From: Jonathan Best <Jonathan.Best@arun.gov.uk>
Sent: 24 September 2026 14:01
To: Planning.Responses <Planning.Responses@arun.gov.uk>
Cc: Hannah Kersley <Hannah.Kersley@arun.gov.uk>
Subject: LU/252/25/RES

Hampton Park Littlehampton.

I have reviewed this application with regards to ecology.

Drawing Title
Proposed Private
Road Lighting
and Illuminance
Layout

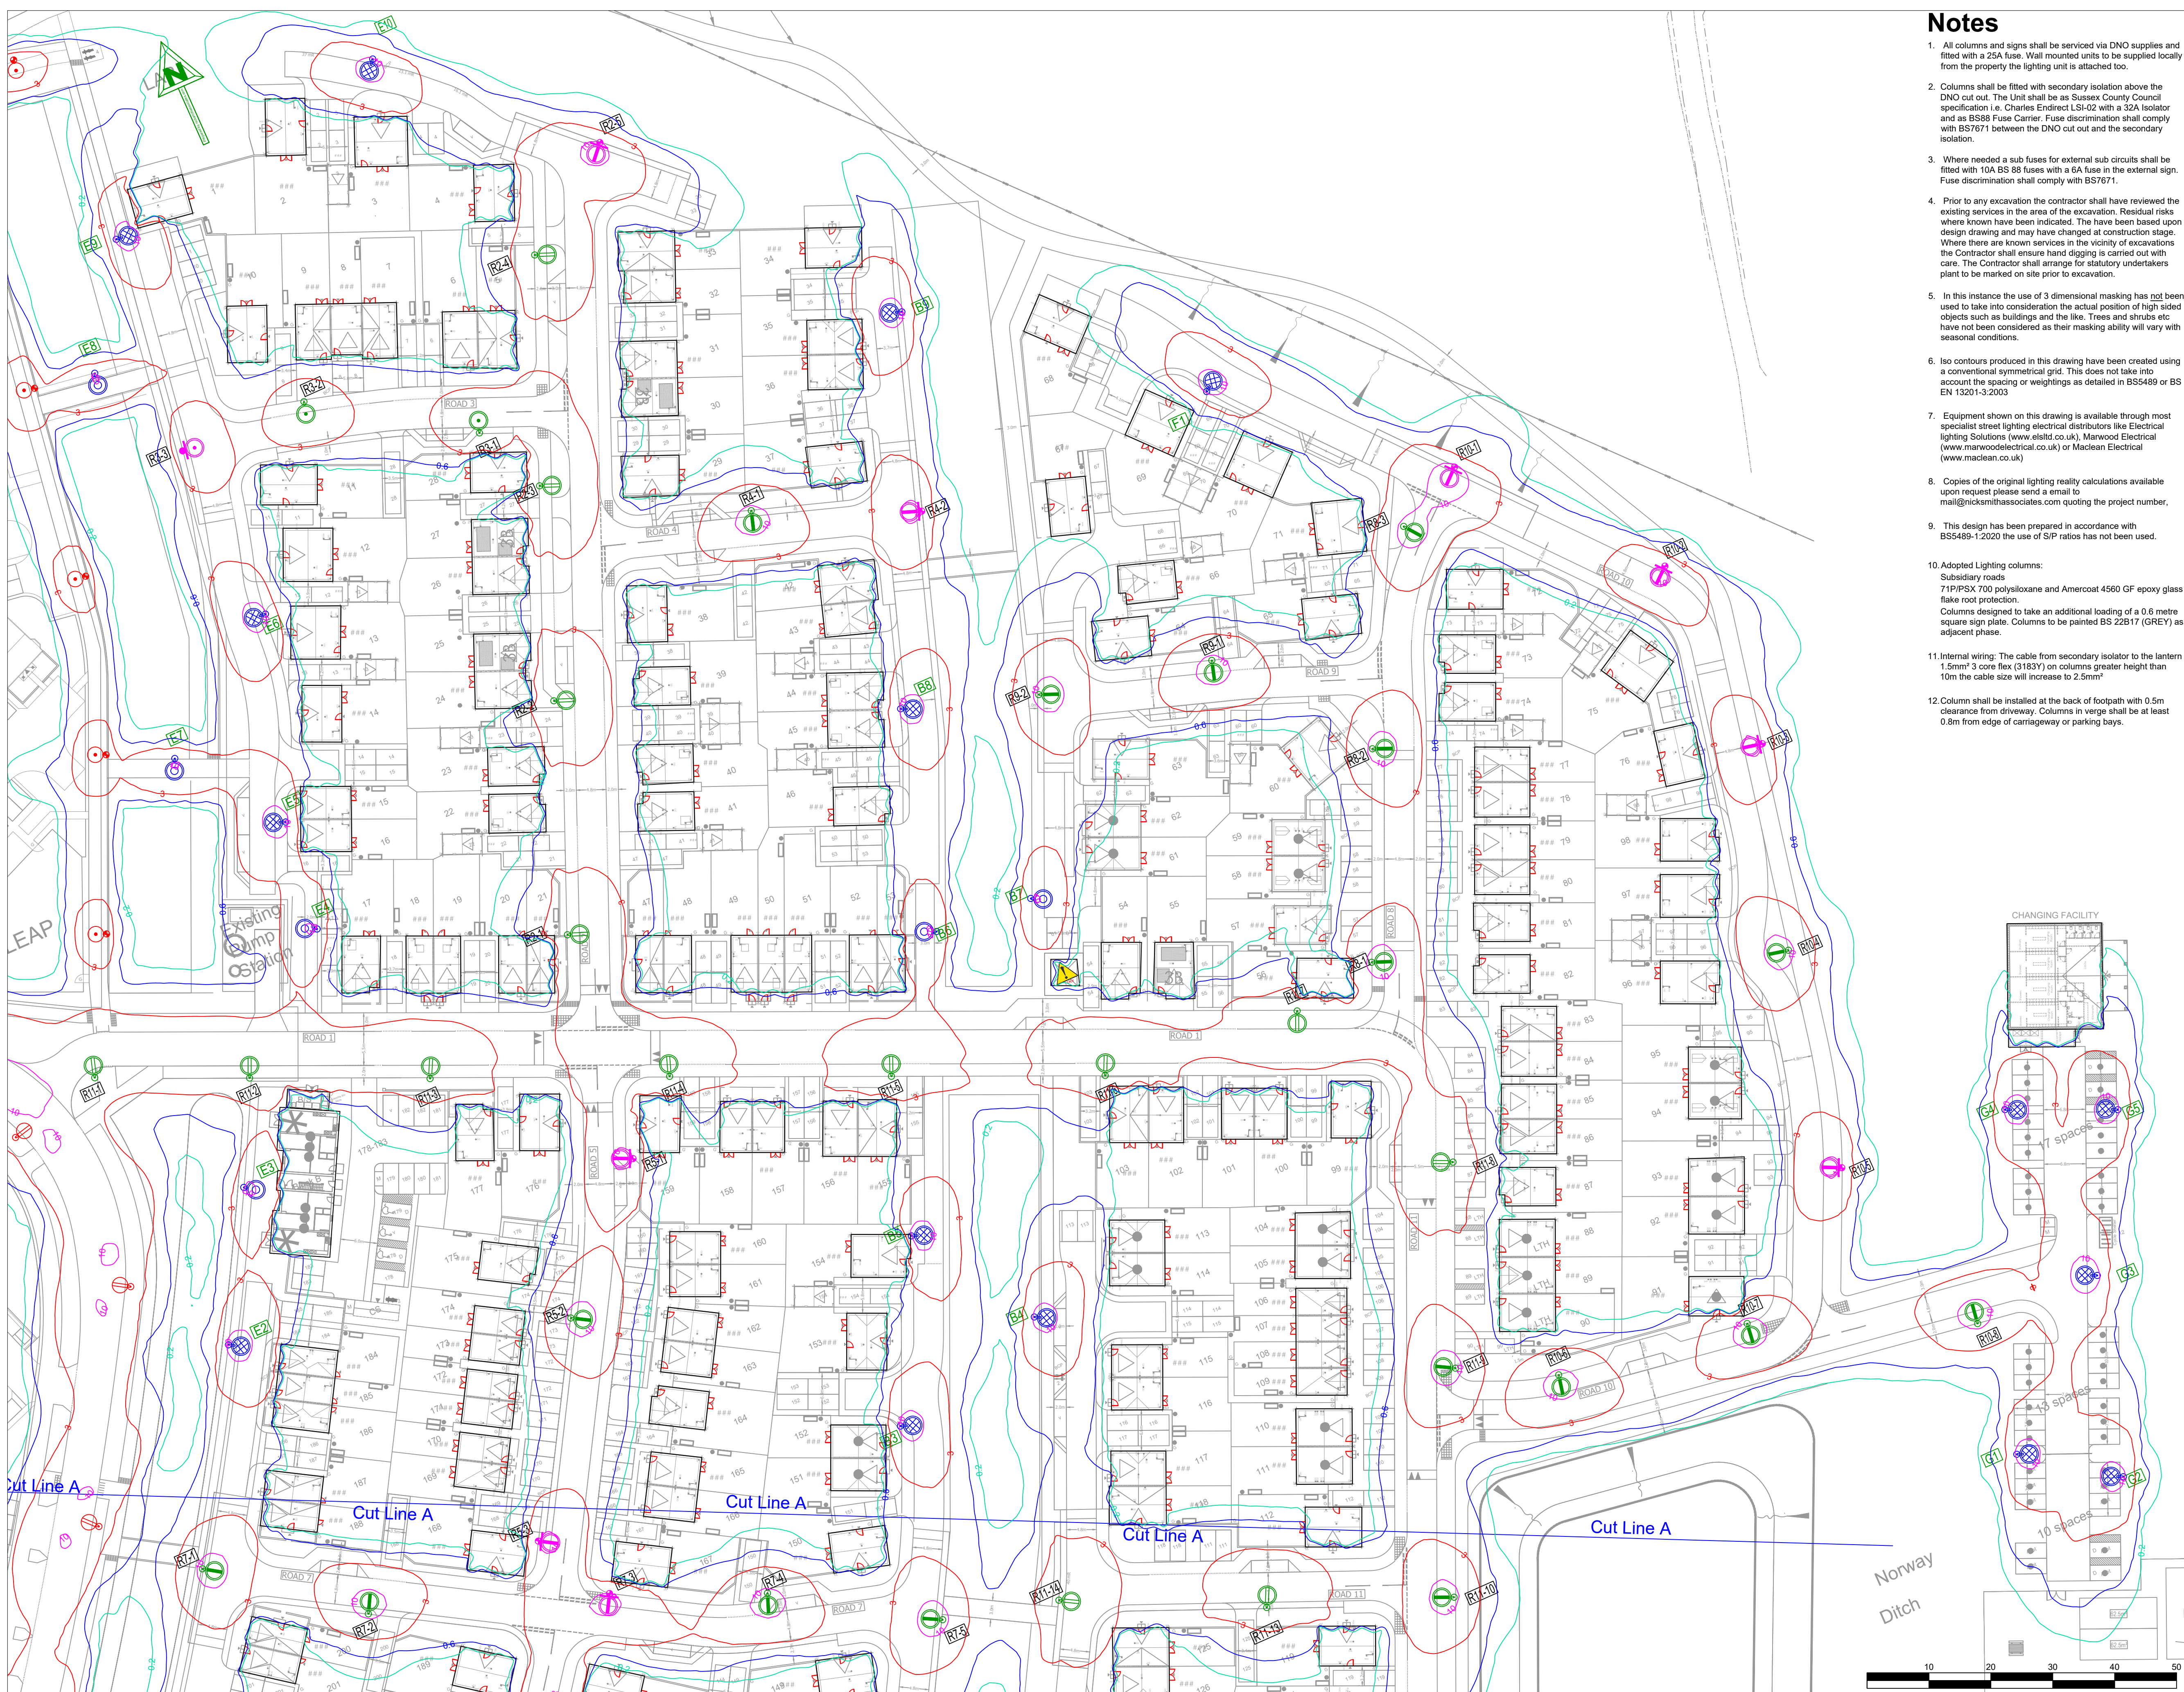
States that 'the proposals will result in the loss of foraging and commuting habitats for bats. New external lighting may cause disturbance to foraging and commuting bats'. The scheme should seek to conform with the recommendations of the Institution of Lighting Professionals (ILP) "Guidance Notes for the Reduction of Obtrusive Light" (GN01:2011) and. "Bats and Artificial Lighting at Night" (GN08 2023).

LITTLEHAMPTON PHASE 6
PLAYING FIELDS
PROPOSED FLOODPLAIN IMPACTS

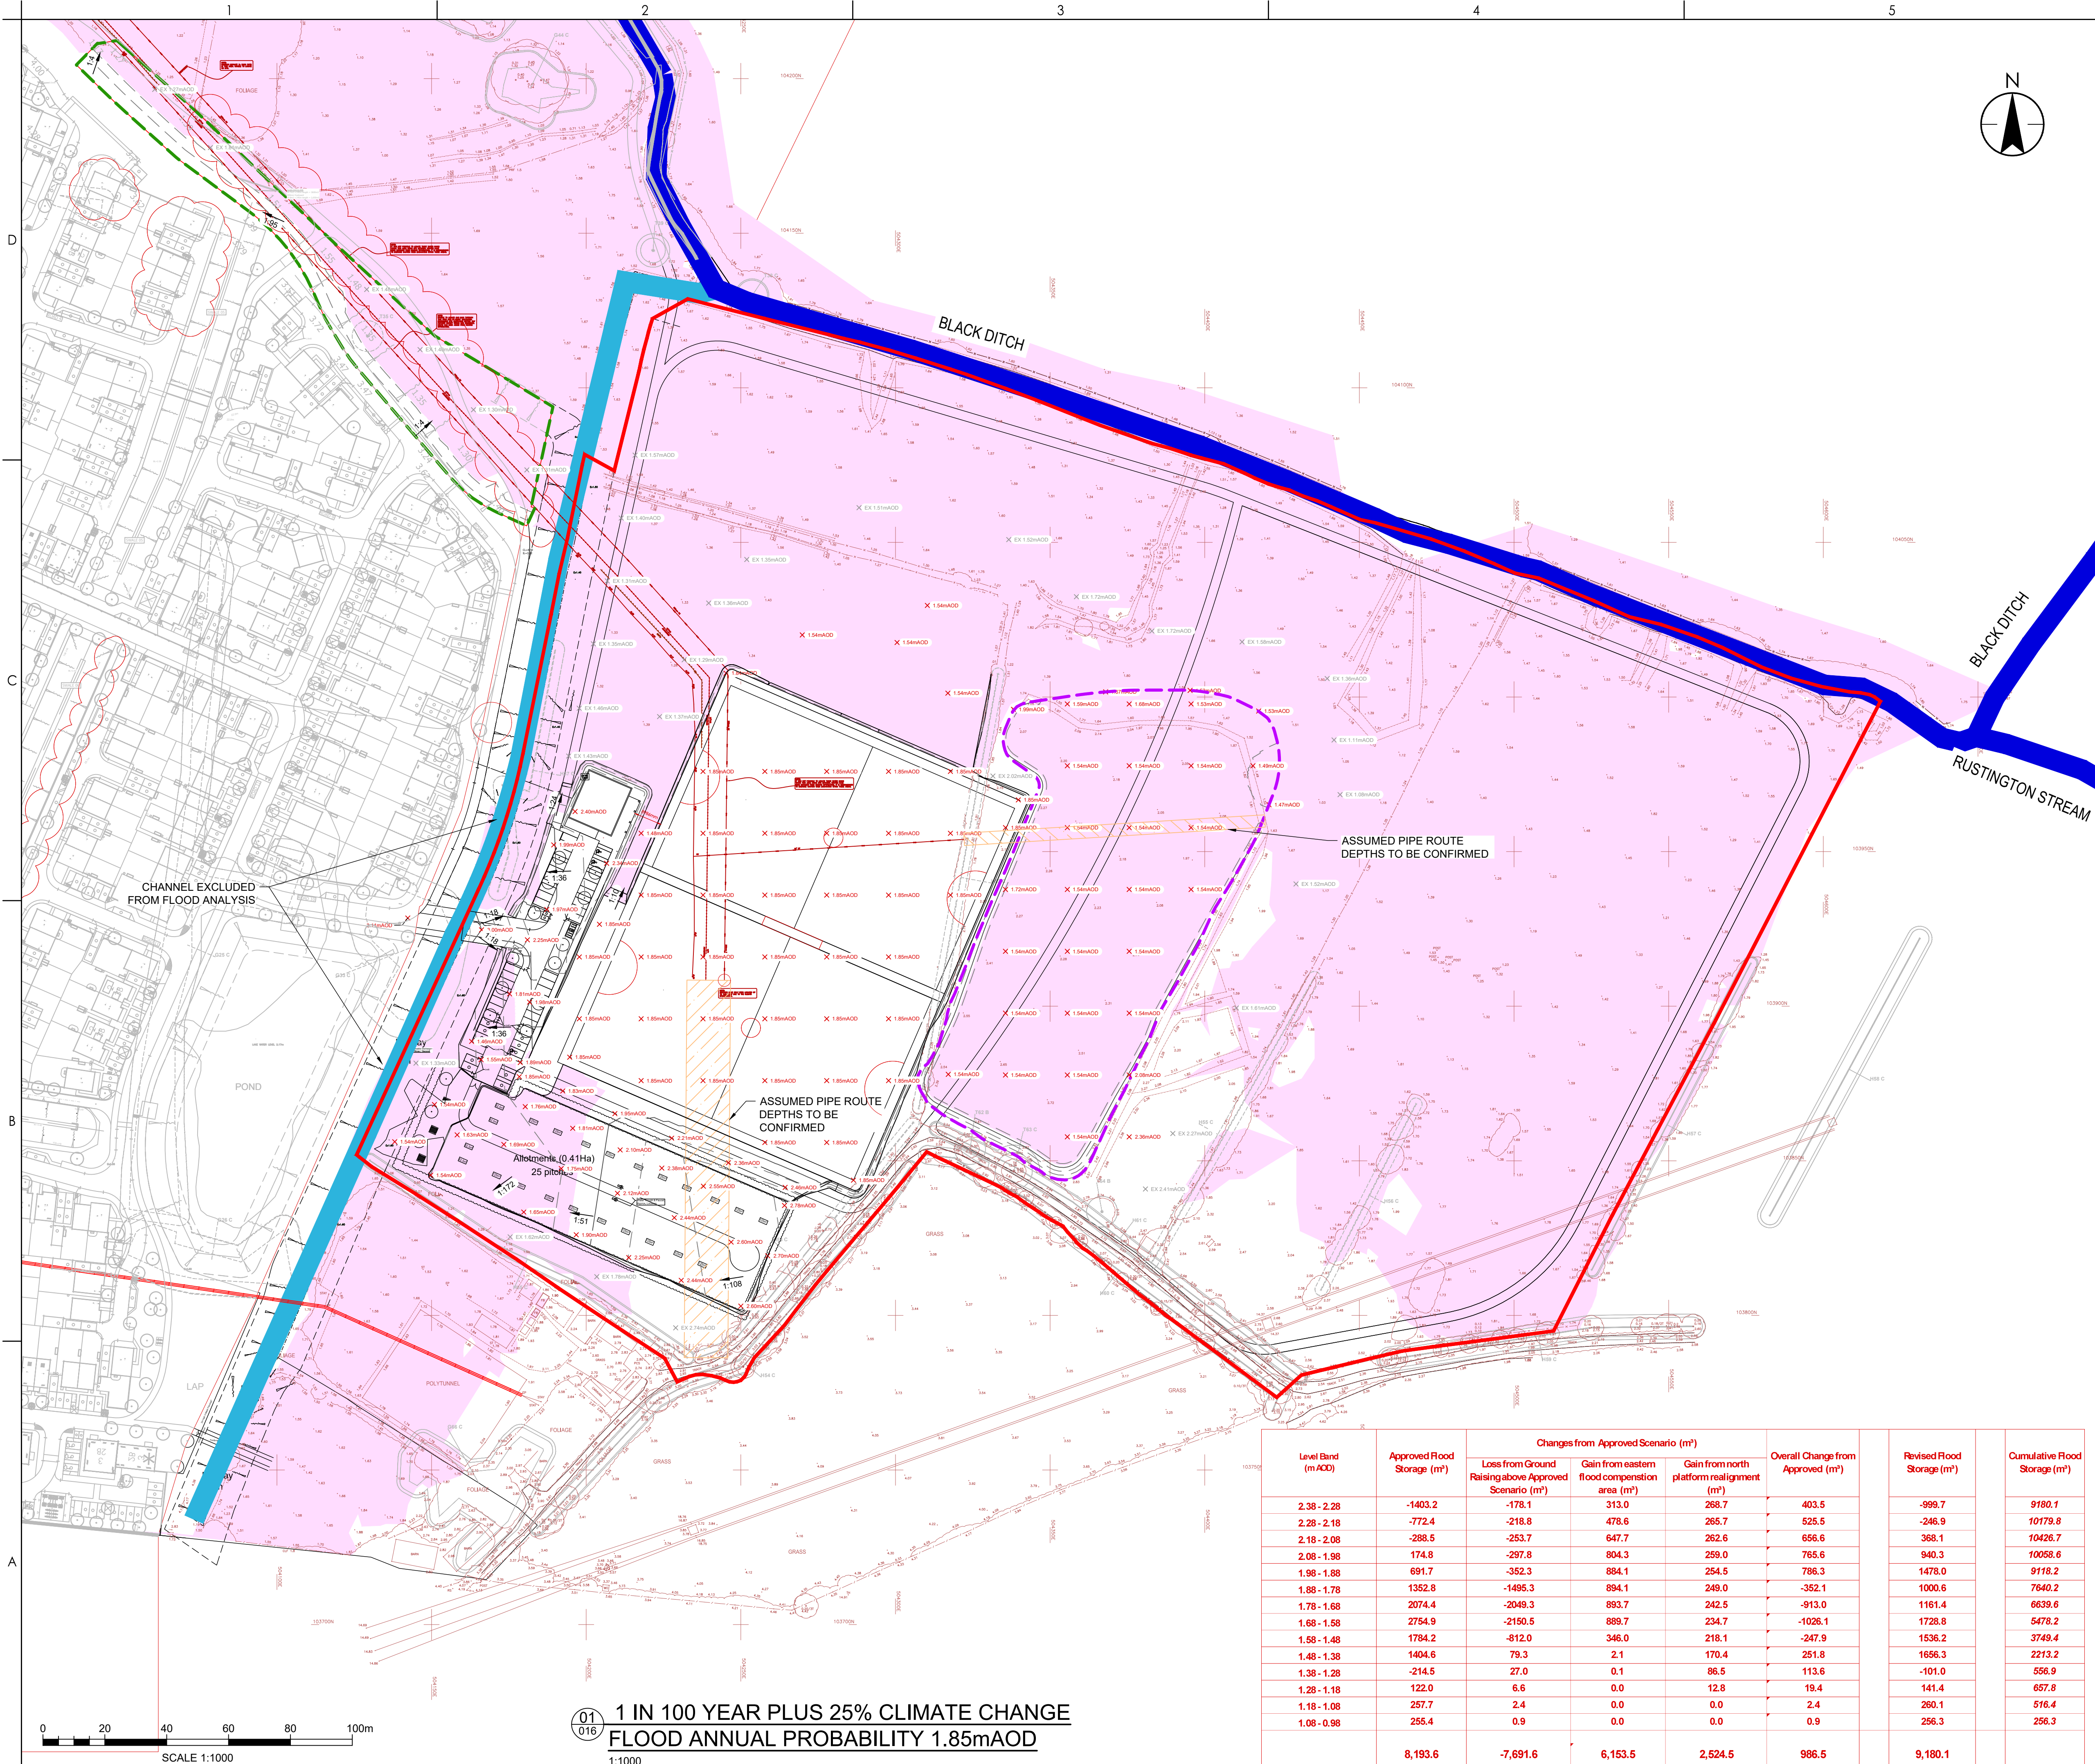
Para 5.9.5 of the EclA states that five hibernacula will be created within the proposed receptor area to provide additional habitats for reptiles and improve the carrying capacity of the site. This is not shown in the Landscape Management and Maintenance Plan (LMMP), but has been identified in maps within the EclA submitted for application LU/249/25/RES. There are concerns regarding the location and design of the reptile hibernacula.

The proposed hibernacula are located in flood zones 2 and 3. This is not acceptable an alternative location not prone to flooding should be identified. Confirmation as to when these hibernacula will be constructed is required.
